**Consultation Response from KC,
Highways Development Management - RK**

2020/92067 former, Stile Common Infant & Nursery School, Plane Street, Newsome, Huddersfield, HD4 6DF

Erection of 30 dwellings

**Date Responded:
21/01/2021**

11293-005 – Forward Visibility on Internal Layout

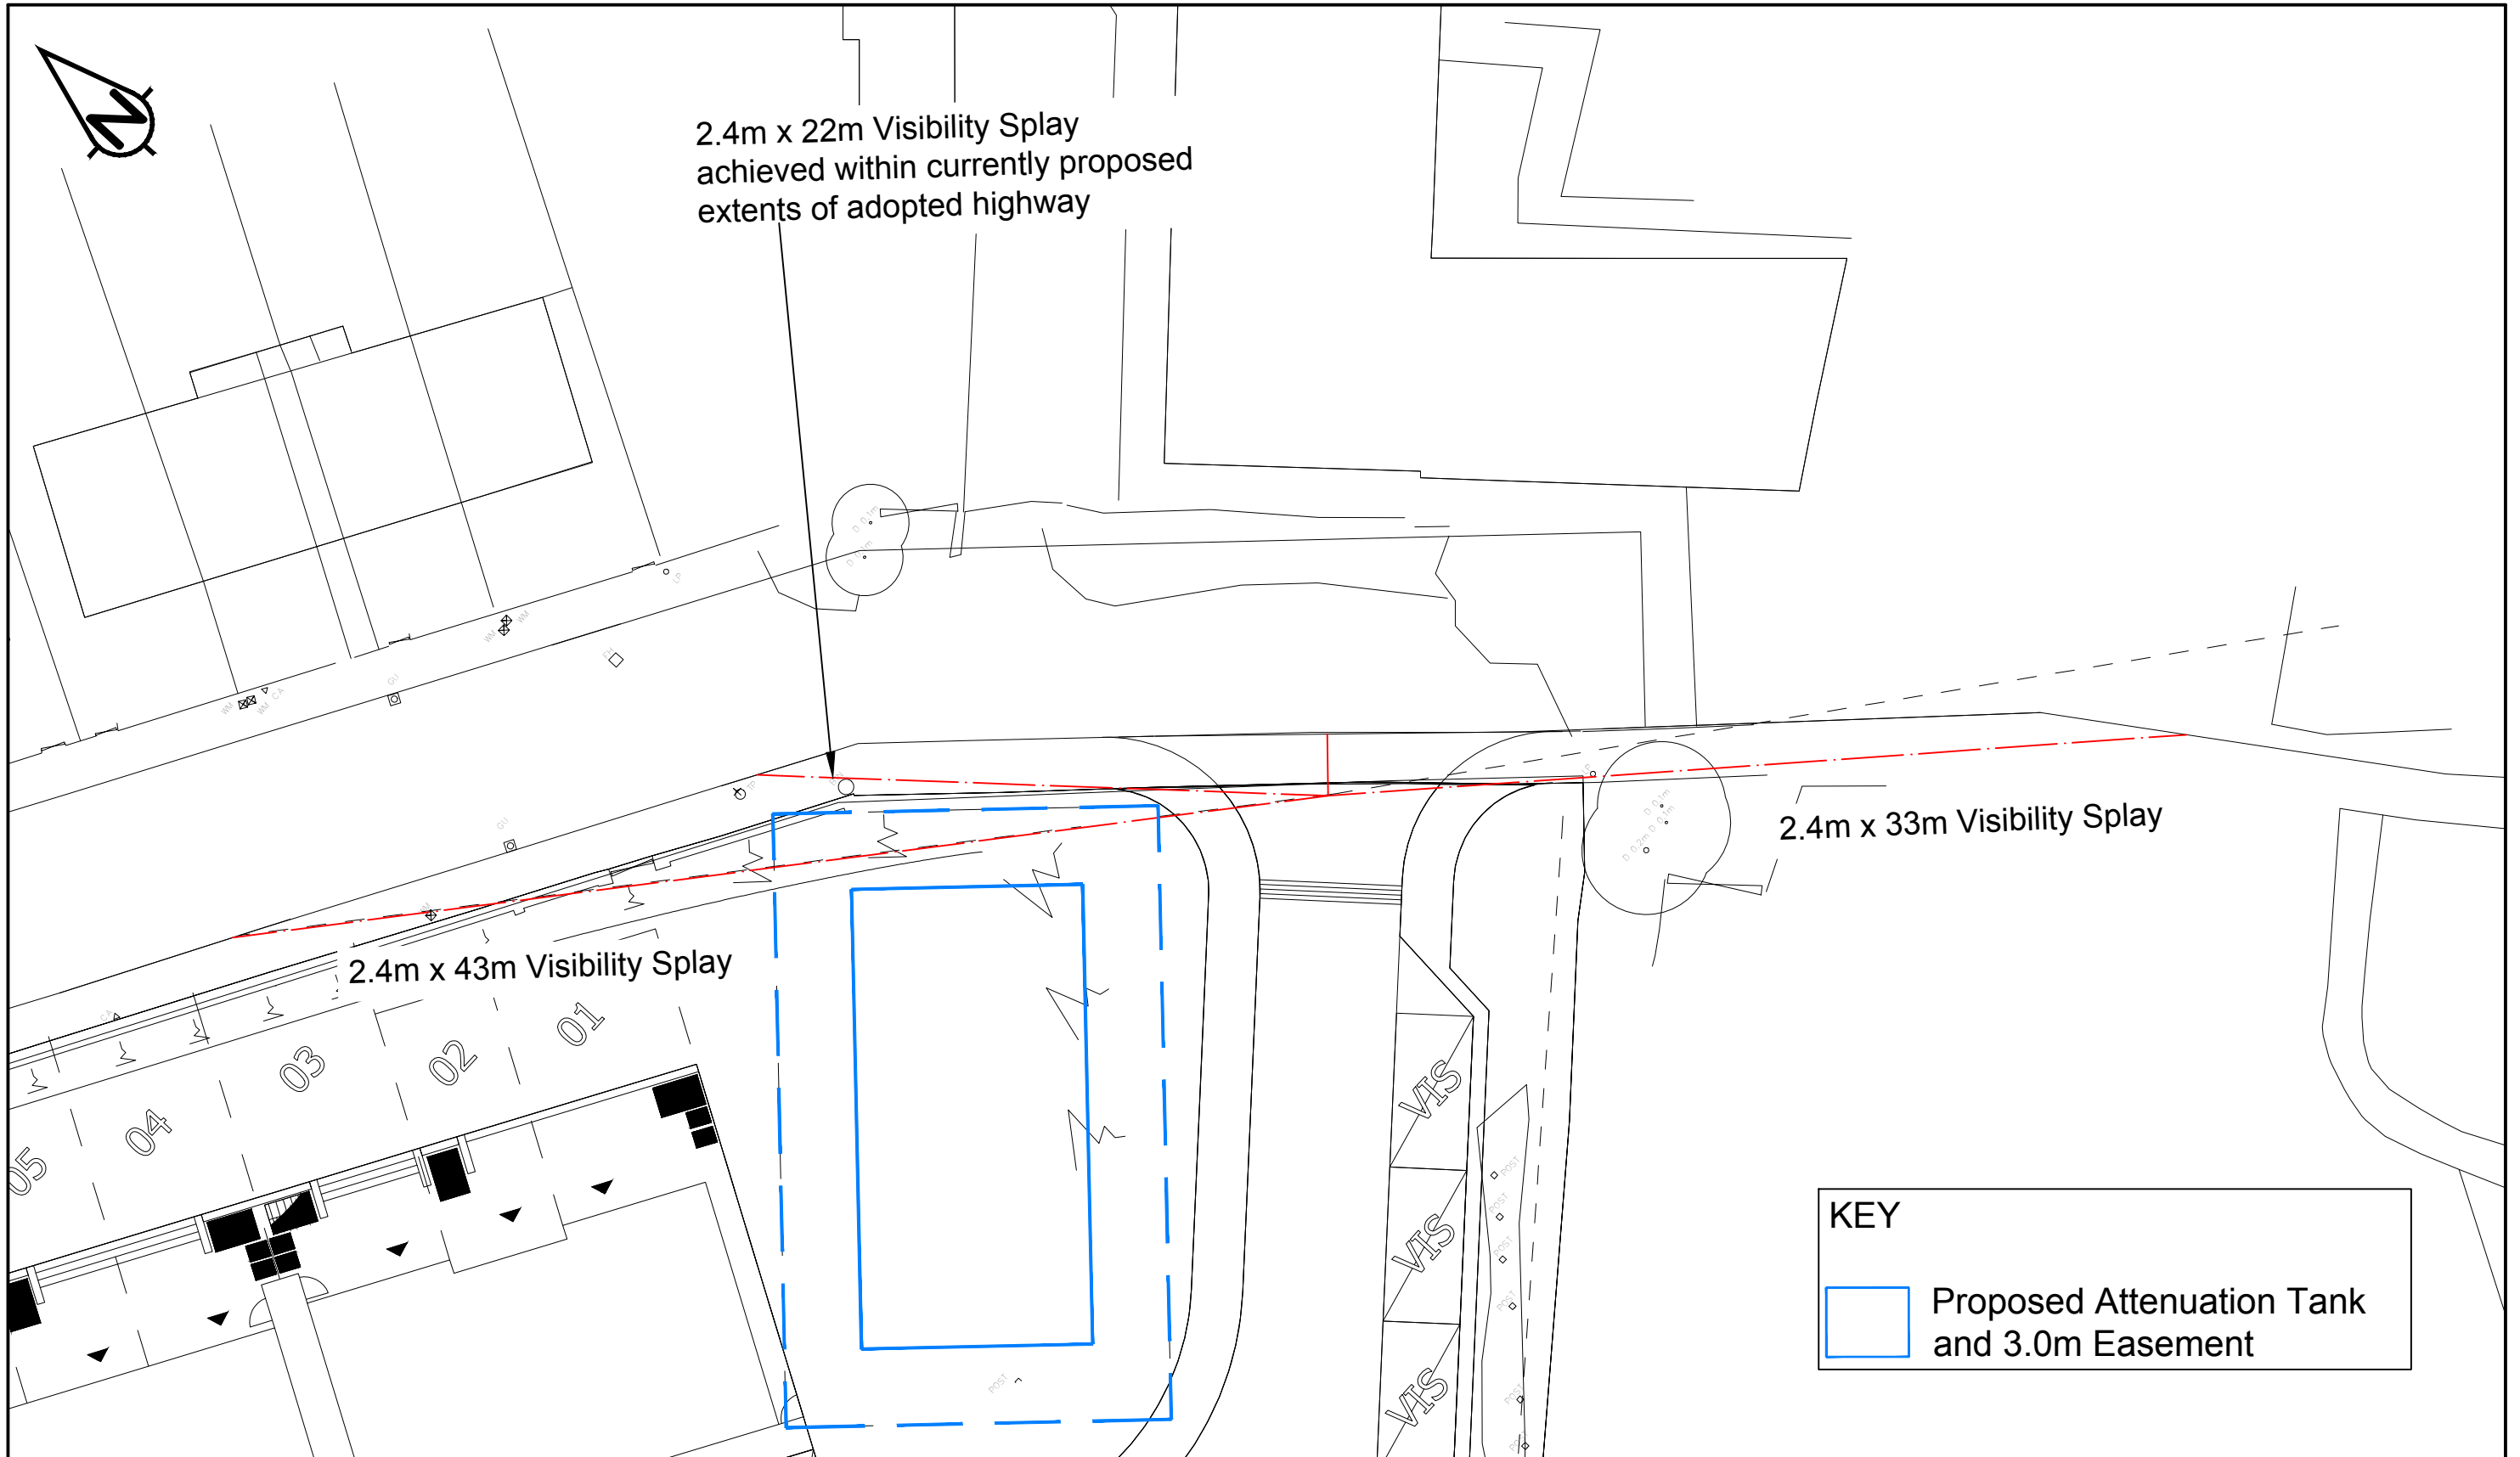
Swept path analysis is provided for an 11.85m refuse collection vehicle, which is welcomed. This

appears to demonstrate the ability for such an RCV to negotiate the site layout and turn around within the site. Whilst there are concerns regarding potential conflict with parked cars, off street parking provision is provided at the end of the turning head, due to access being needed for this it is considered no cars will park in the turning head itself and thus remain free of obstruction.
